Submission Regarding Application SSI-7485-Mod-2

I object to the proposed Modification 2 to the M4-M5 Link on a number of grounds, the first and foremost being that it represents the worst aspects of ad-hoc design, destroys the intent and functionality of the approved plan, wrecks the balance achieved in the original planning process and represents a betrayal of the promise made to the local community.

Figure 4-2 The Crescent/Johnston Street/Chapman Road layout in EIS and proposed modification model

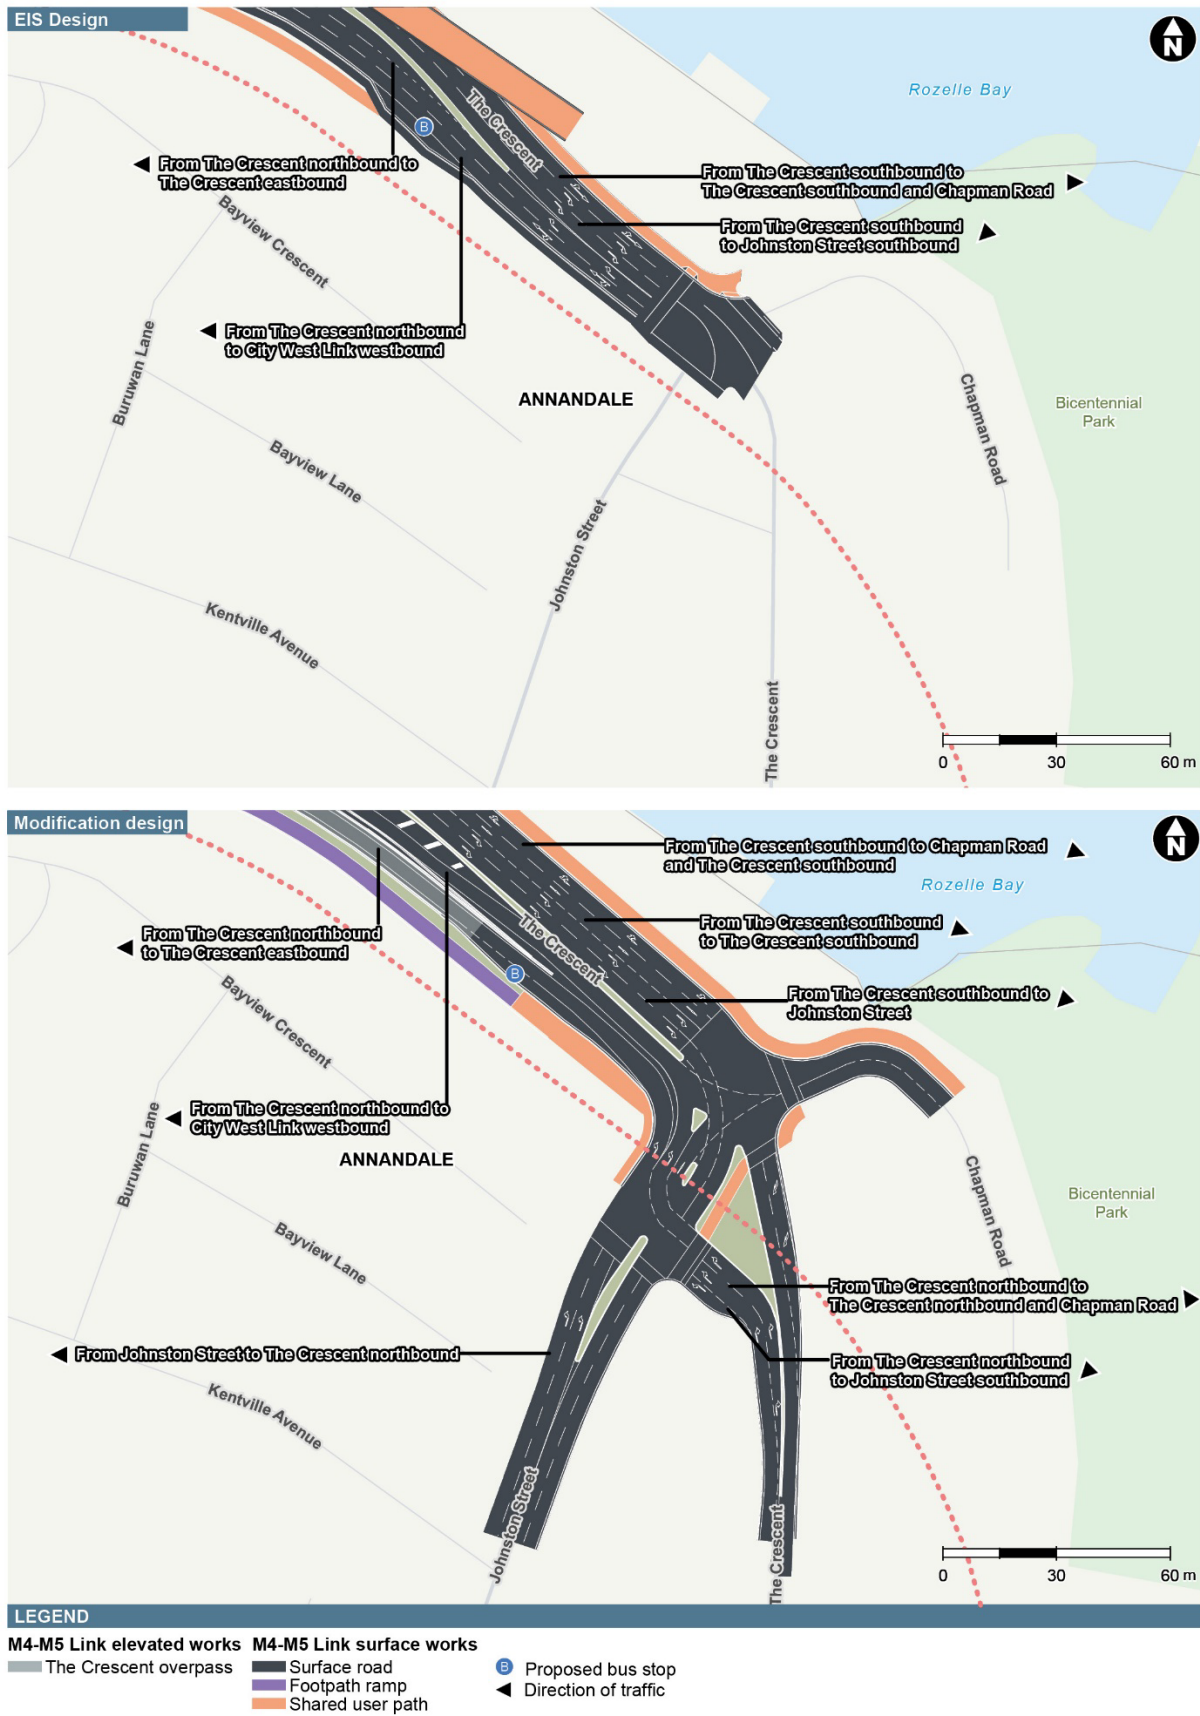
The Mod 2 proposal would create an extremely dangerous situation at the tight corner under the railway bridge (see image above and point A in the image below). The Mod 2 proposal plan proposes that two lanes of traffic would merge into one on a sharp blind corner with huge brick columns that support the railway bridge.

This is a clear project risk and also pointless. The Crescent is one lane each way under the railway bridge and for the next half a kilometre (see image below).

The Mod 2 proposal proposes to have northbound traffic along the Crescent make three awkward sharp turns to continue along the Crescent instead of the single corner under the railway bridge as per the current situation and approved plan. (see item B on the image below)

The Mod 2 proposal presents this reduction of traffic amenity as required because of a proposed second turning lane, however the second turning lane is pointless because the Crescent is single lane. (see image below of car turning right into the Crescent)

Figure 4-3 The Crescent, Johnston Street, Chapman Road intersection options

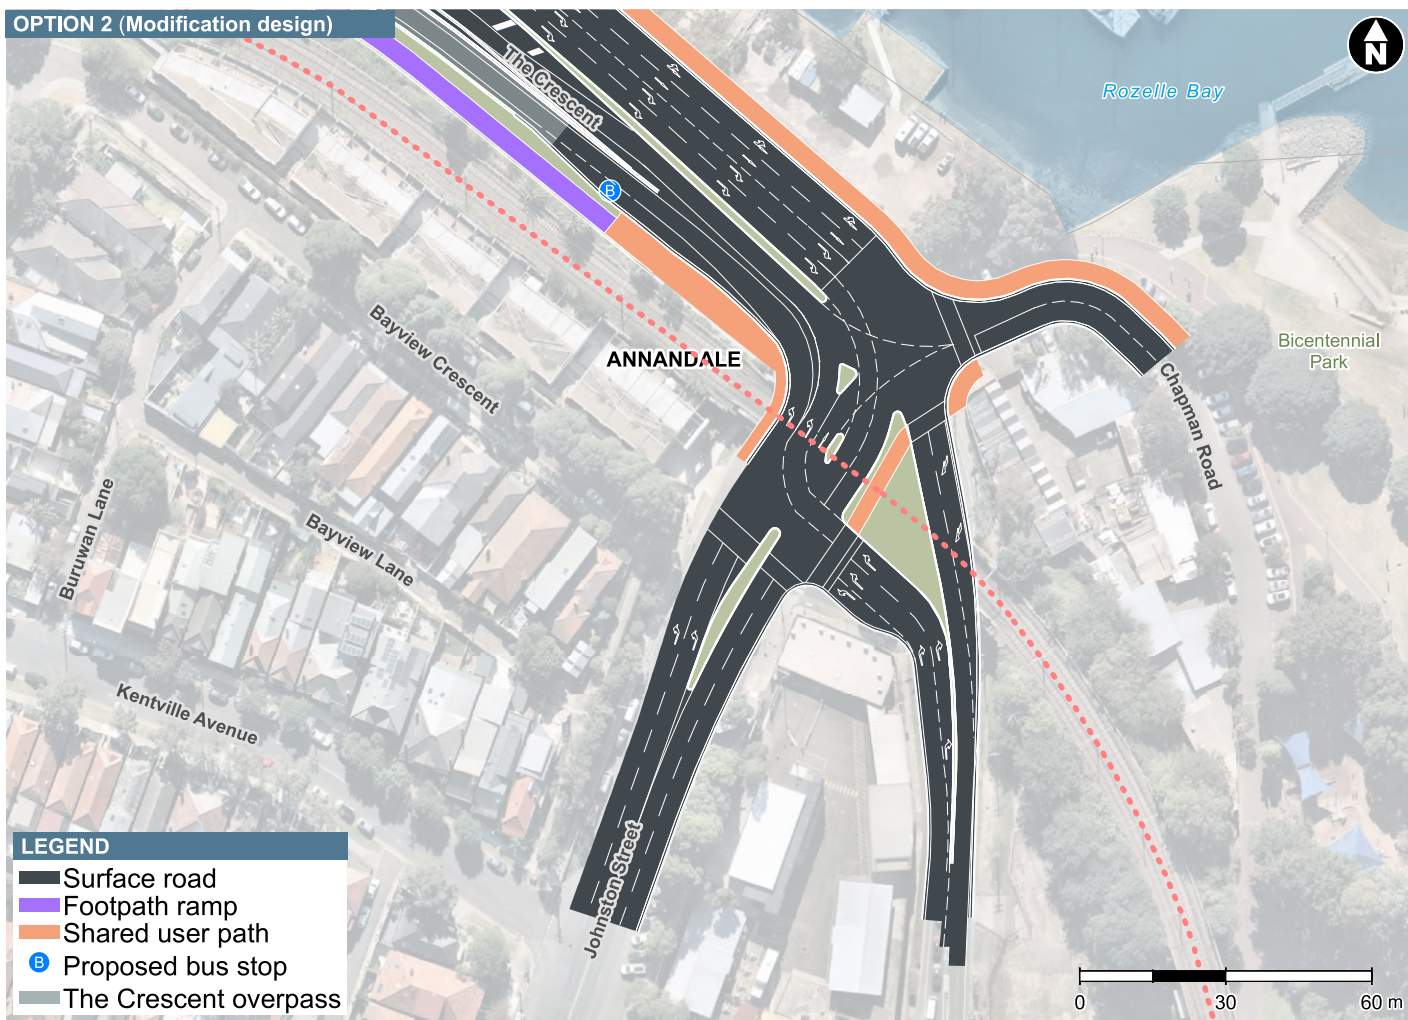
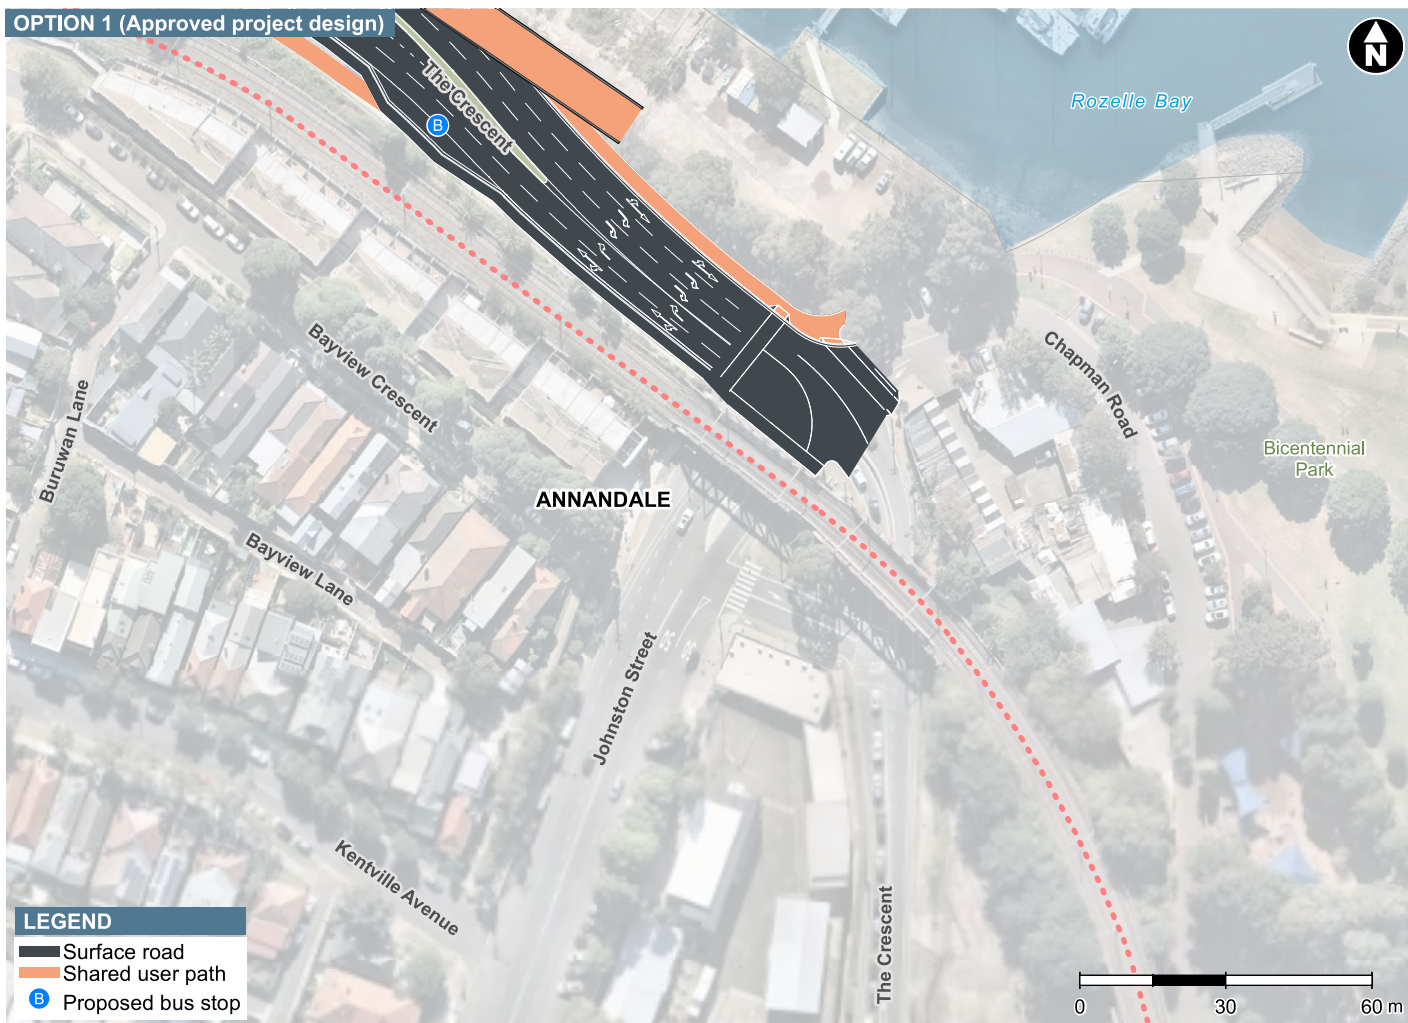
The approved plan retained the single pedestrian crossing to the foreshore however the Mod 2 proposal misrepresents the proposal's quadrupling of the time it would take for pedestrians to reach the foreshore at ground level with the following dismissive, unquantified and inaccurate statement.

*"This option would result in a **slightly longer** pedestrian movement to cross The Crescent near Johnston Street. The at-grade crossing would be removed from its existing location. Pedestrians would be required to cross at the existing at-grade crossing over Johnston Street to a new at-grade crossing at The Crescent, and then cross Chapman Road at the existing at-grade crossing. "*

Nothing is gained by this proposed change. The proposed car overpass is totally unaffected if the single street level crossing of the Crescent is retained as per the approved plan. At present the single pedestrian crossing of the Crescent is timed to coincide with the movement of traffic exiting Chapman Road. In the Mod 2 proposal traffic on Johnston St and the Crescent would still have to stop to allow cars and trucks to exit Chapman Rd, so the proposed change is pointless and the time for pedestrians to reach the foreshore and park would be quadrupled not just "slightly" as the proposal proports.

Again this poorly conceived change reduces traffic flow rather than enhances it. Large trucks and buses would have difficulty navigating the snaking path proposed and since **the Crescent is one lane each way heading South** there is nothing to be gained by the convoluted proposal.

There is also a major traffic flow loss from the proposed change, a loss that cuts off the community from access to the Crescent from Johnston St. Currently cars and trucks can turn right from Johnston St to the Crescent and this was also part of the approved plan. This access is used by traffic to reach Glebe, The Tram Sheds shopping centre, The University of Sydney and other locations.

*This option removes the right-turn movement from Johnston Street onto The Crescent southbound. Only a limited number of traffic movement would be impacted, and alternative traffic routes are available.*

Again the Mod 2 proposal provides no evidence for its assertions and misrepresents the reality. The proposed change is totally unnecessary and in fact trebles the driving distance required. As an example to reach a location like the Tram Sheds shopping centre from the corner of Johnston St and Kentville Ave., Annandale the current journey is 900m whereas the Mod 2
